Historic England

27 September 2022

### **Arrangements for Handling Heritage Applications Direction 2021**

**YEW TREE FARM, ADJ 63, THE VILLAGE, FARNLEY TYAS, HUDDERSFIELD, HD4 6UQ**

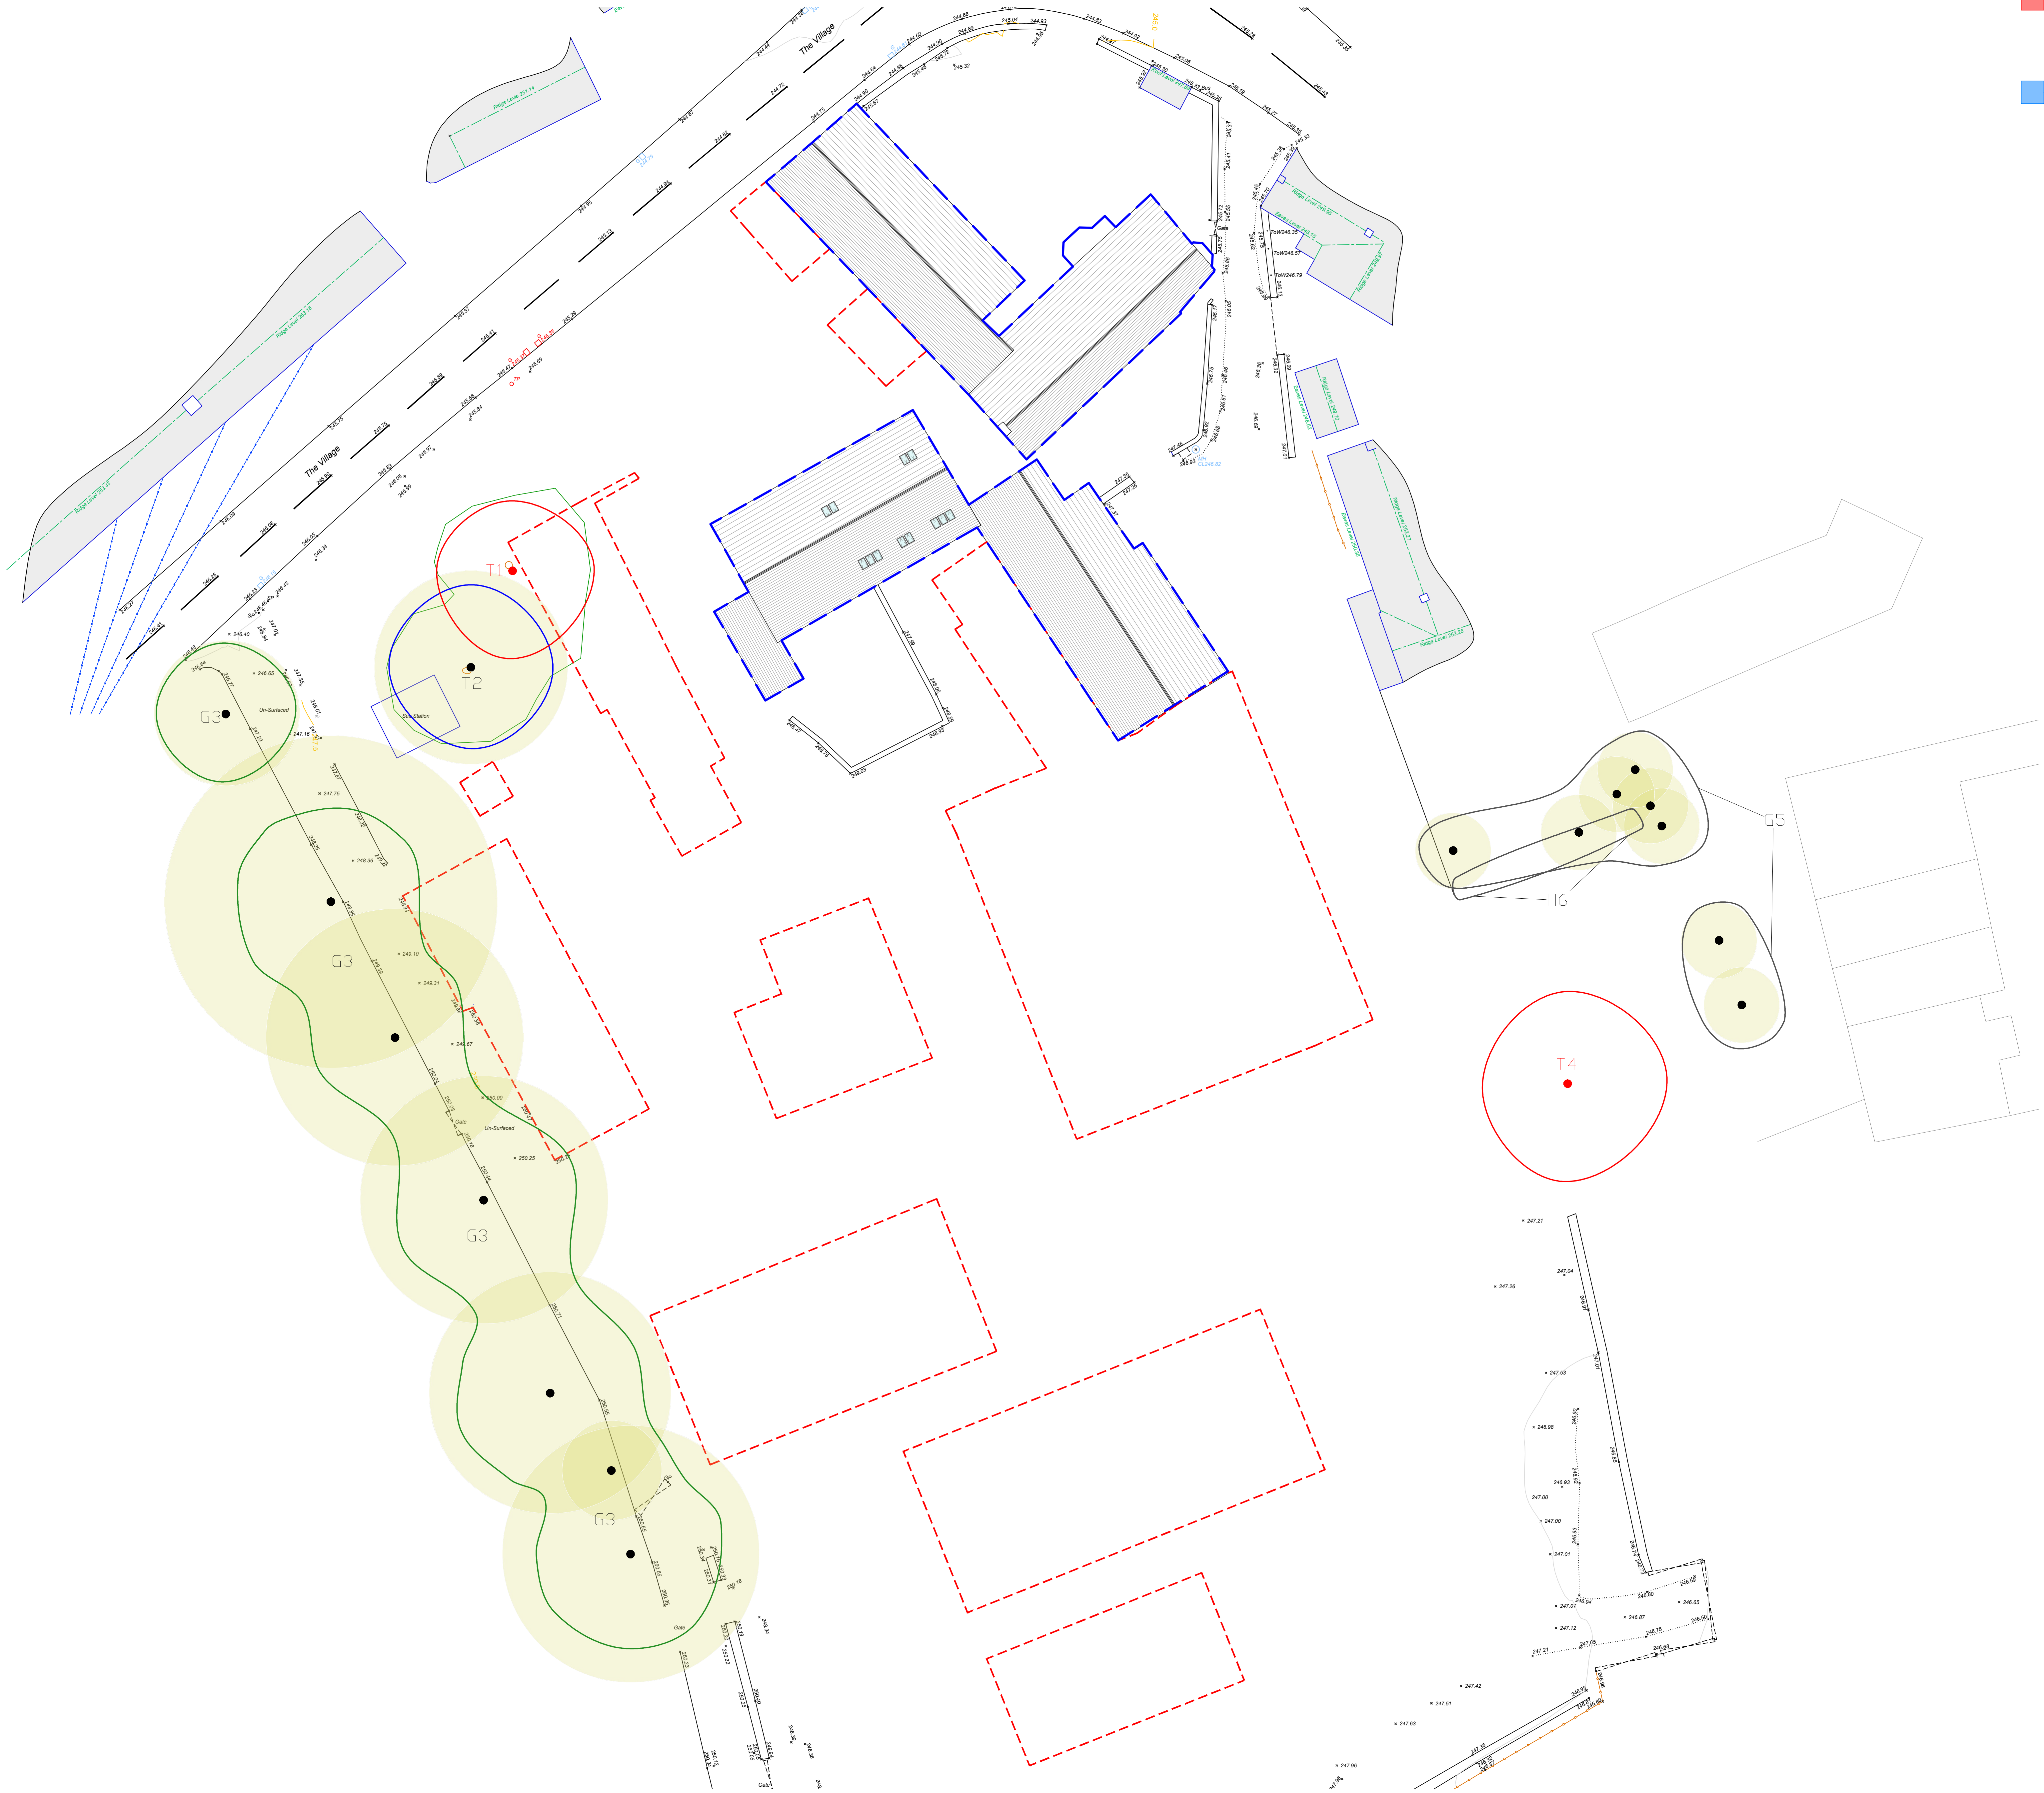
The demolition of the unlisted farmhouse would lead to the loss of an undesignated heritage asset and harm the character of the conservation area. Your authority should robustly assess the justification for the loss of the farmhouse. If you consider a case has been made, we recommend stonework from the existing farmhouse is used in the reconstruction of the house on the proposed new alignment.

We recommend your authority robustly assesses the case for demolition of the historic, unlisted farmhouse. If you consider a case has been made, we recommend mitigation in the form of building recording and the reuse of materials in the rebuilding of the house on a new alignment.
